**CHENNAI METROPOLITAN DEVELOPMENT AUTHORITY**

**Letter No. CMDA/PP/MSB/N/0803/2019**

Sub: CMDA – APU – MSB(North) – Planning Permission Application is for the construction of Basement floor + Stilt cum Ground floor + 8 floors + 9th floor (Part) – Residential Building with 152 Dwelling units, Retails shop in Stilt & 1<sup>st</sup> Floor, Multipurpose Hall, Gym, Indoor Games, Home theatre in 1st floor at Old Survey No. **200/2A2A** (part) & 2B, Ward No. J, T.S. No. **82/2** & 89 of **Thiruvottriyur Village**, Ennore Expressway, Thiruvottriyur Taluk, Chennai applied by **(1) M/s.Provincial Investment Corporation (P) Ltd** Represented by N.Sivakumar and **(2) Ms.Prakirti Agarwal**- Forwarded to Govt. for approval – Reg.

SITE CUM STILT FLOOR PLAN
ALL DIMENSIONS ARE IN METER
SCALE 1:100

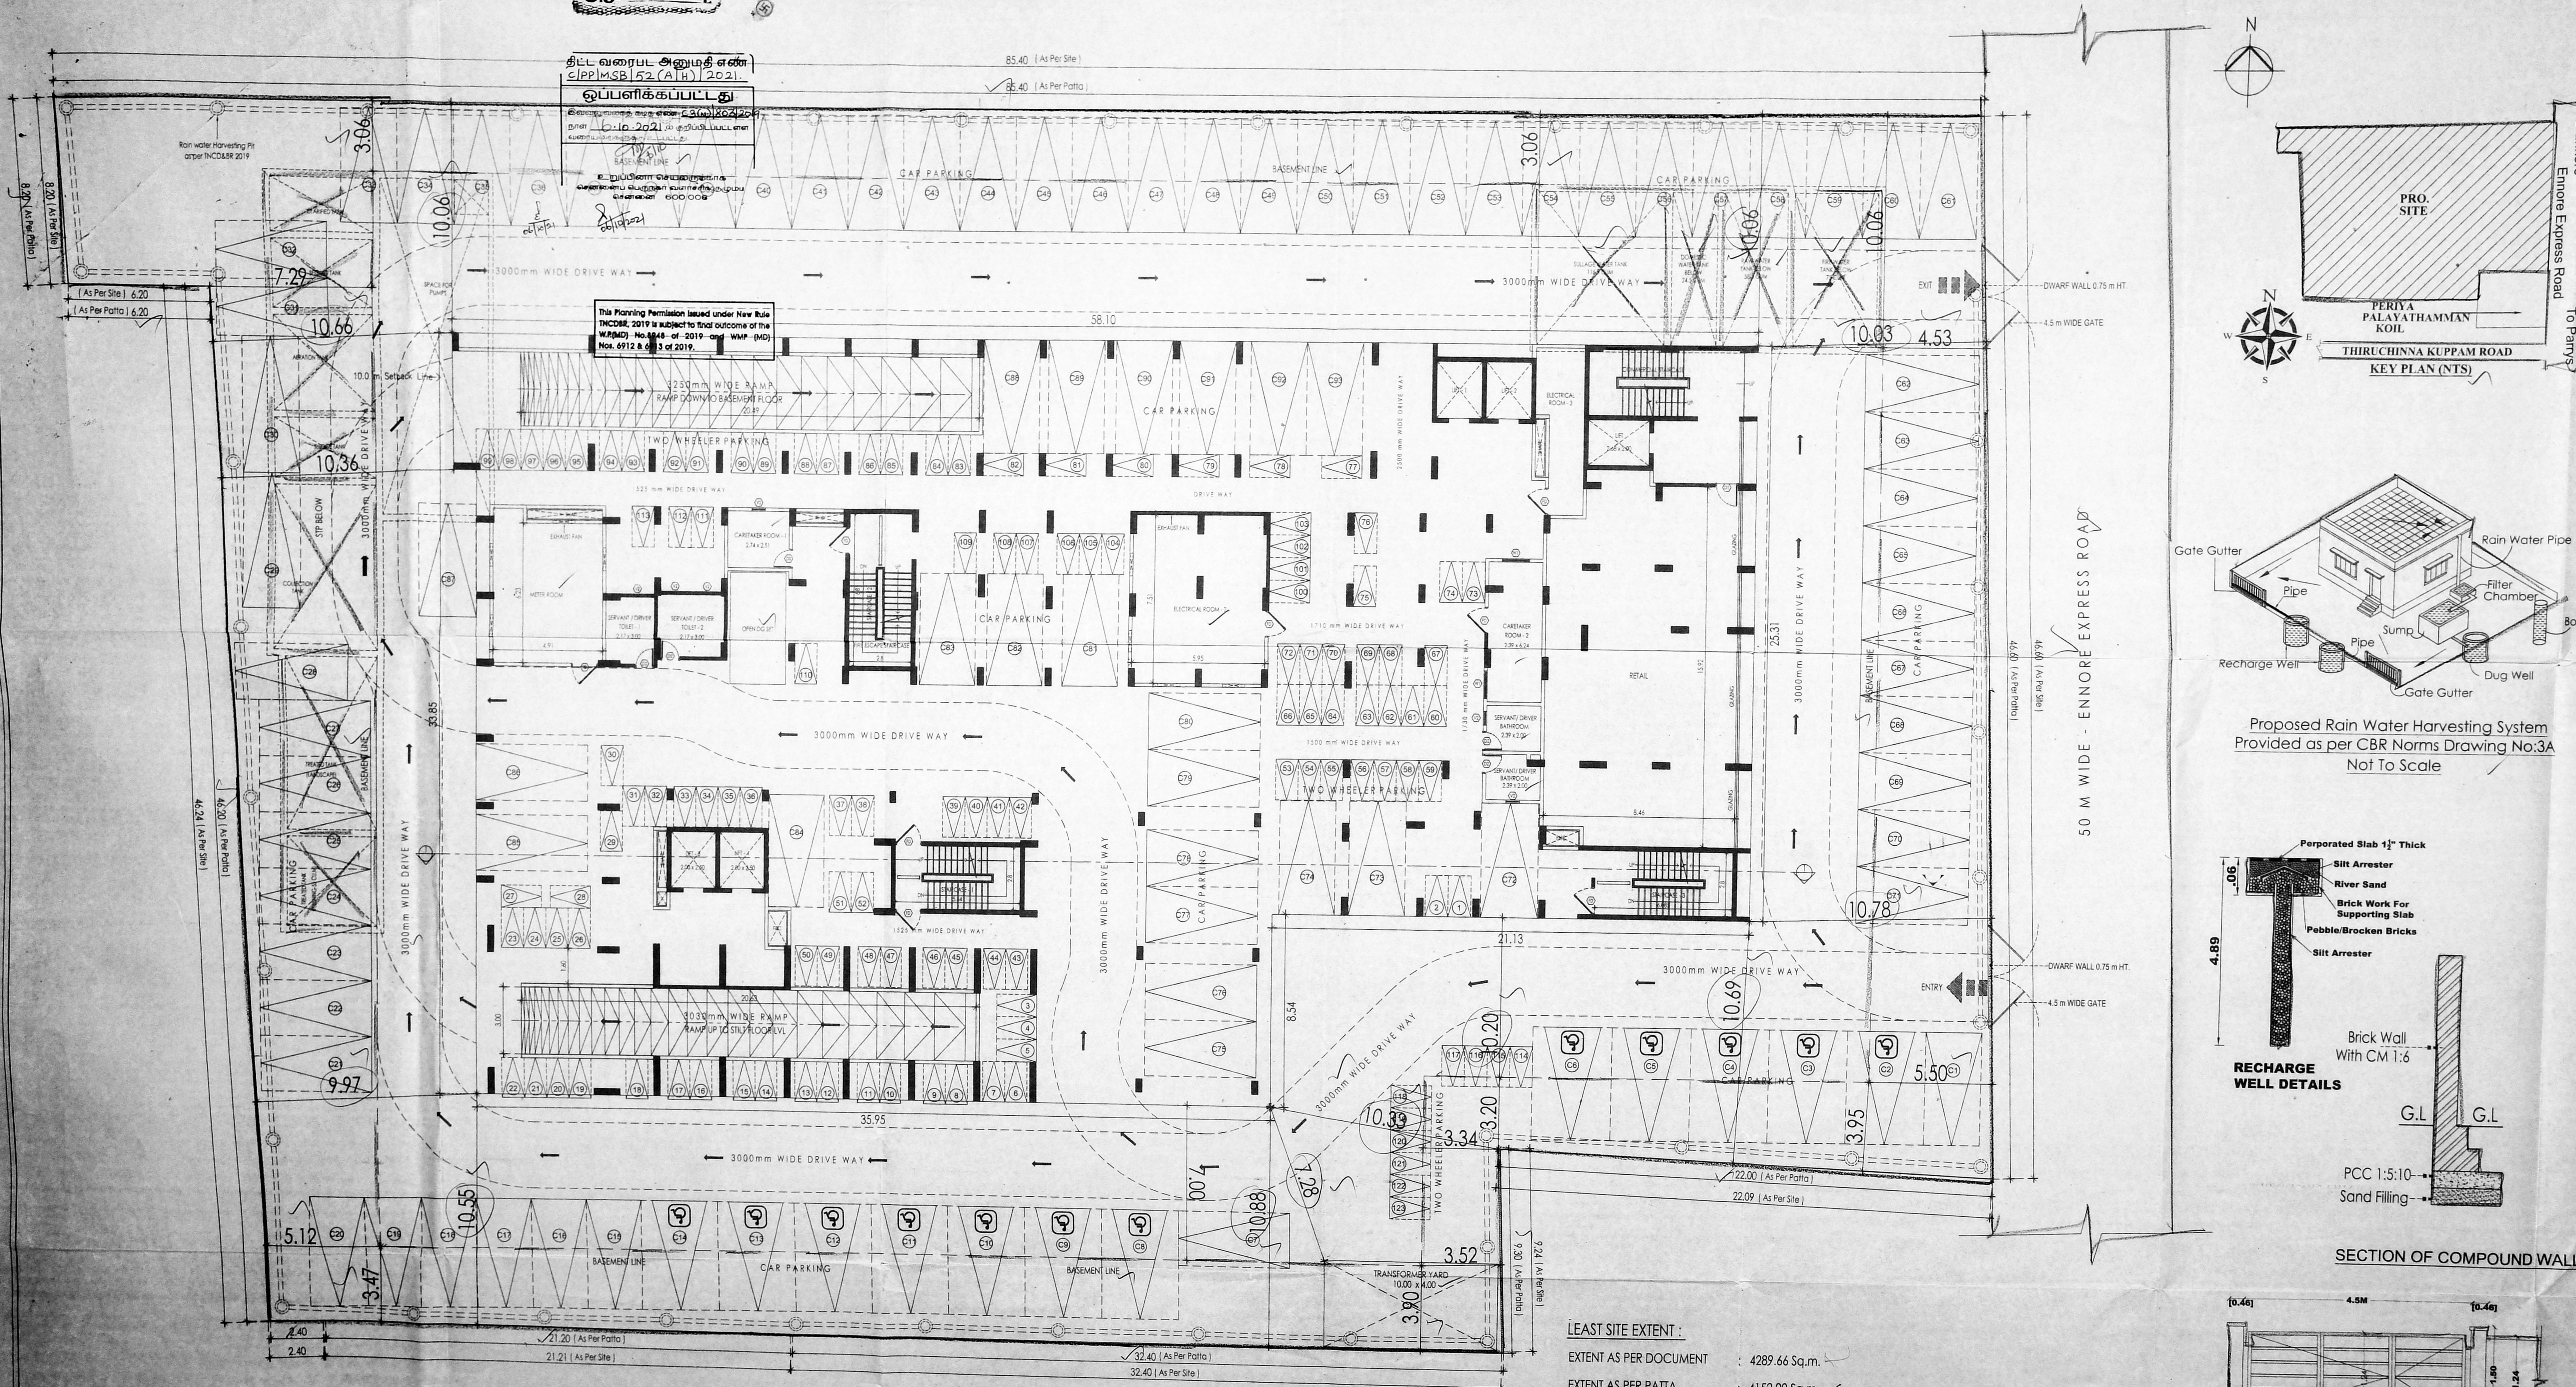
- (iii) Sump for Fire Fighting and Sullage treated water are to be shown with detailed plan.
  - (iv) Length of Ramp to be mentioned in Stilt Floor and Basement floor plan.

- (xii) Lift Lobby shown in Stilt & Basement floor are to be removed.
  - (xiii) Parapet height to be mentioned.
  - (xiv) Section along Ramp to be furnished in plan.

- (xv) Distance between the building & Transformer yard to be mentioned in the site plan and a minimum of 7.00m to be maintained.
2. The applicant has furnished Thoraya Patta issued in favour of M/s.Provincial Investment Corporation (P) Ltd for Survey No. 200/2A of Thiruvottriyur village & in favour of Ms.Prakriti Agarwal for Survey No. 200/2B of Thiruvottriyur village both duly attested by Revenue officials not below the rank of Deputy Tahsildar. ~~Hence~~ <sup>Howeey</sup>, remarks from Tahsildar to be obtained on the status of Thoraya Patta issued.

BASEMENT FLOOR PLAN

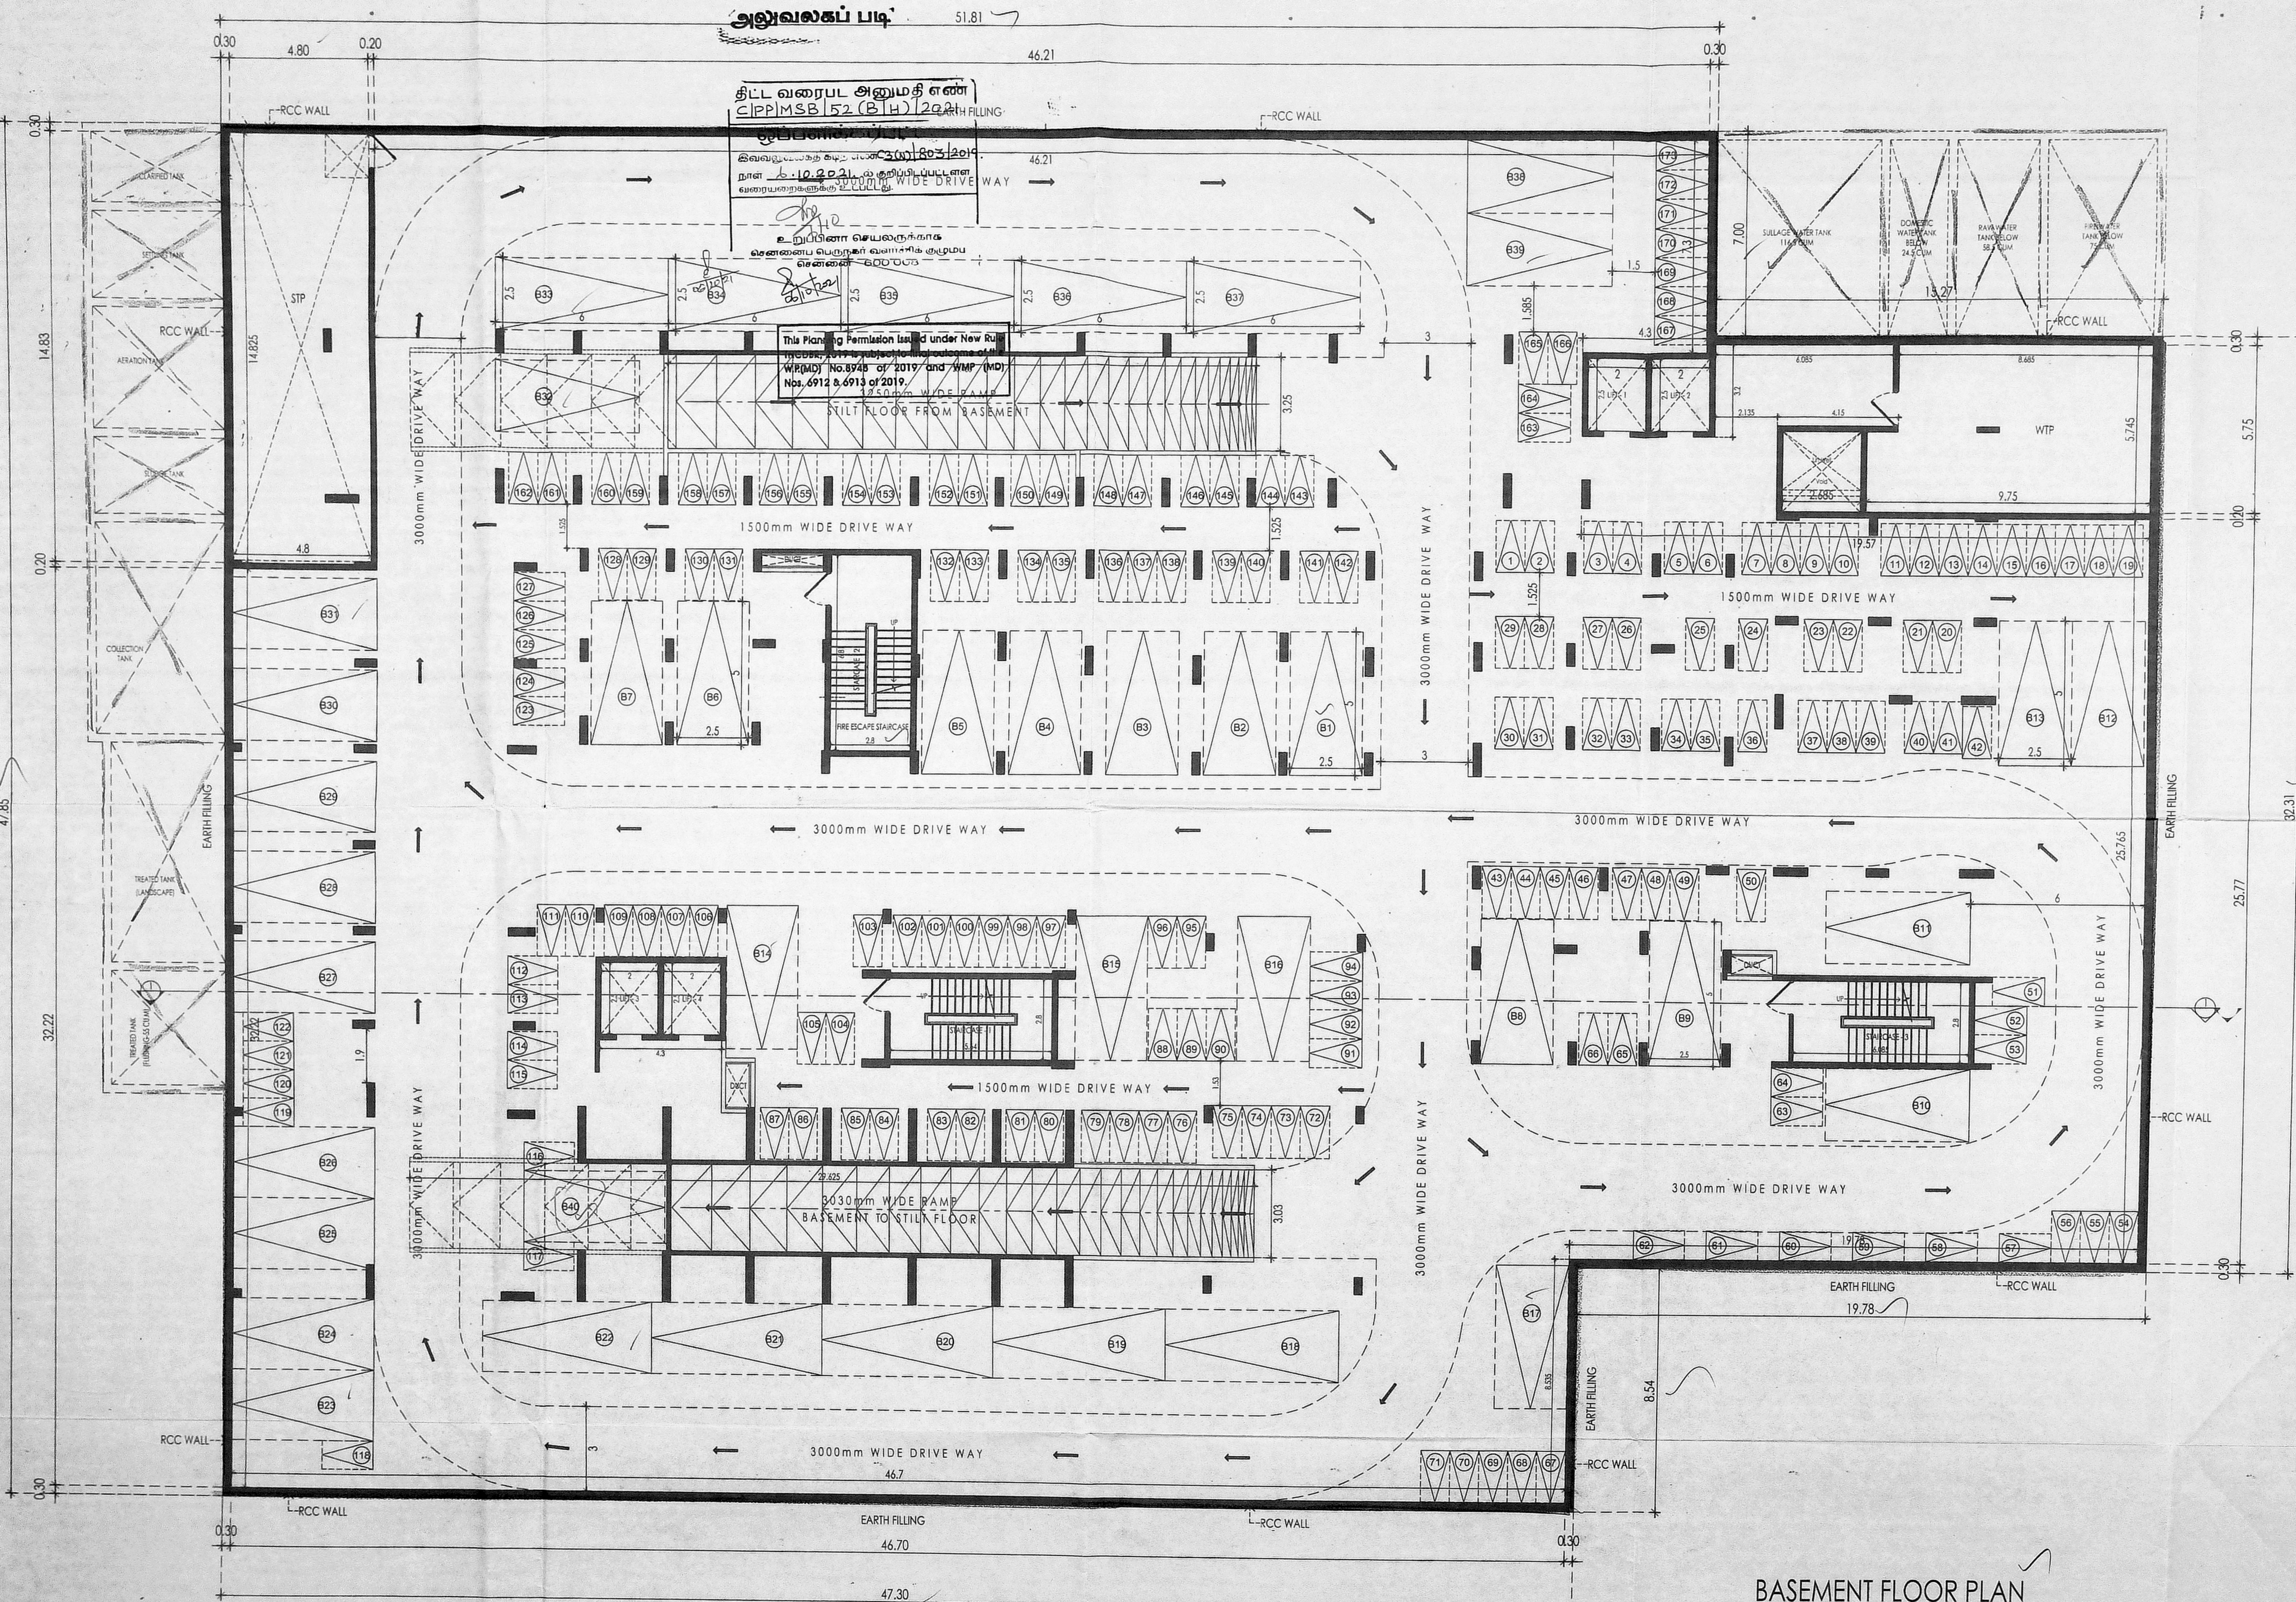
1. Drafting defects in the revised plans:
  - (i) Fire Escape staircase to be indicated in all floor plans.
  - (ii) STP Pump room provided in Basement floor Plan to be removed as STP.

NINTH FLOOR PLAN

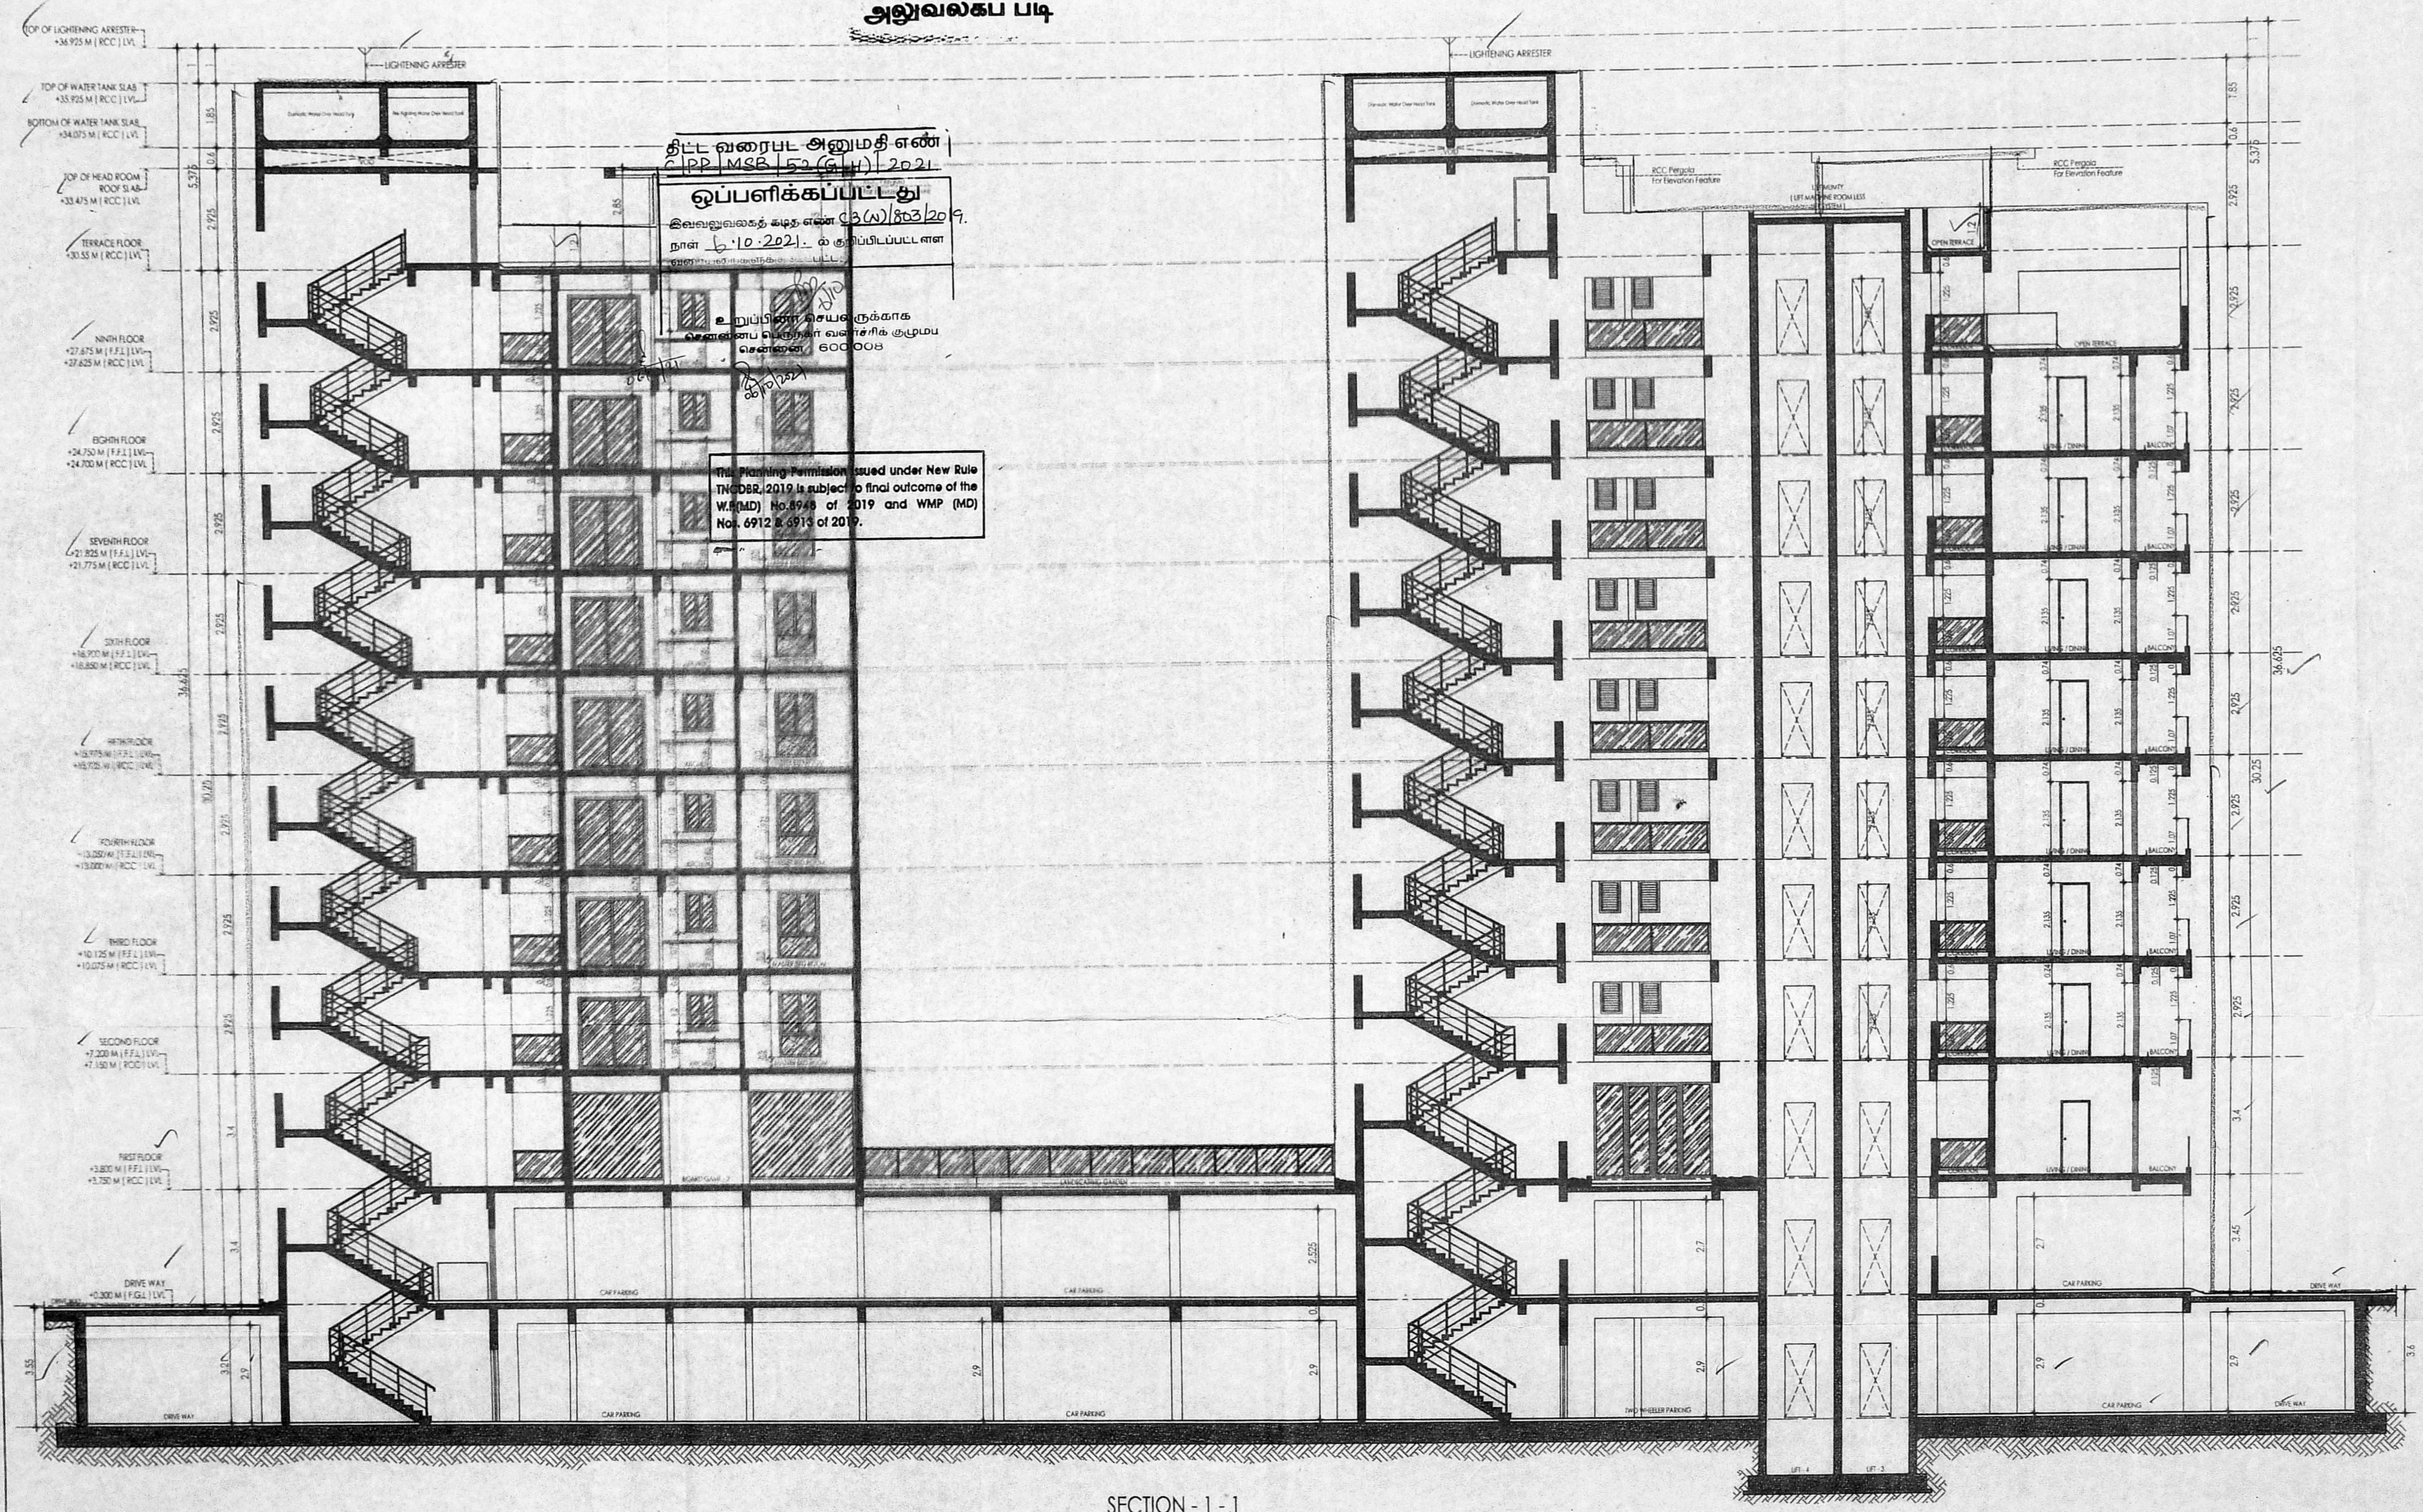
- (v) Over head tank (OHT) for Fire Fighting water and Rain Water Harvesting are to be shown in Terrace floor plan.
  - (vi) 9th floor plan to be shown as per the uploaded Pre DCR drawing.
